| Application number: 2025/92848 | |
| What is the application for?: | Erection of single storey rear extension with balcony, conversion of car port in |
| Address of the site or building: | 17, Kensington Close, Staincliffe, Batley, WF17 7RL |

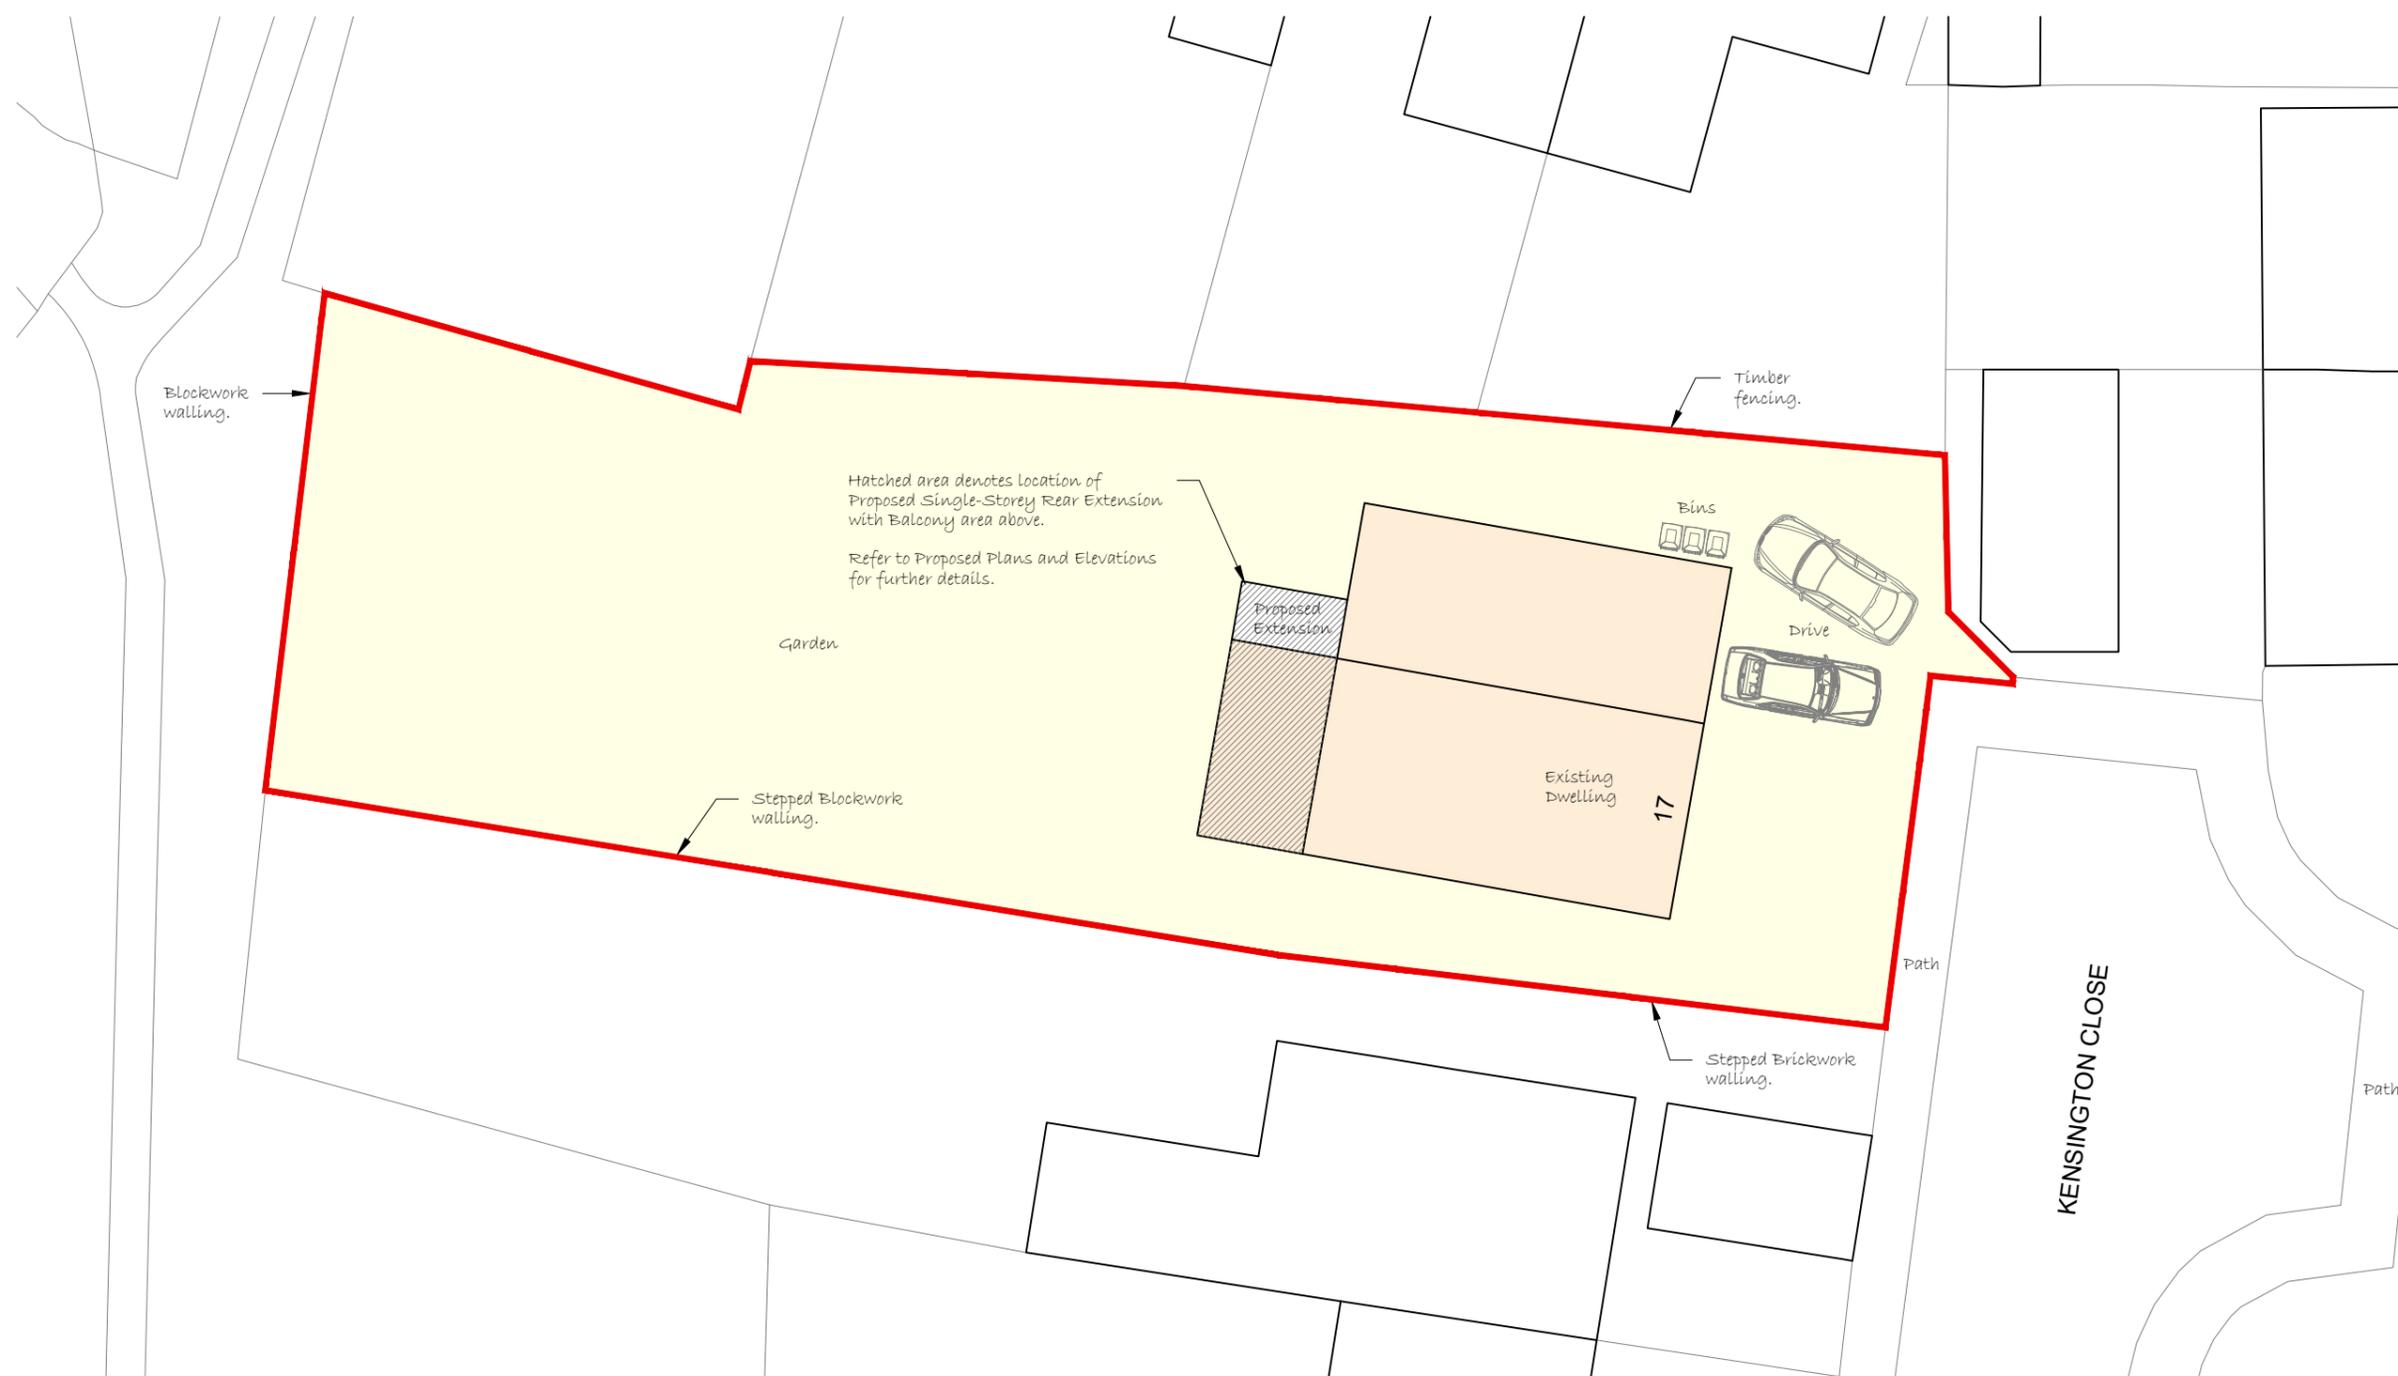
| <p>According to plans, no provisions have being made for cars to be parked on the drive as the car port is being converted into a room. The street is a cul-de-sac and residents of the street go to the bottom of the road to turn around their cars to go out. If there's more than 2 cars parked outside it makes it very difficult. Also theres access for a house which is situated on clerk green who park at the bottom of the street as well to access the back of their property. Also works have already started without planning being passed.</p> | |
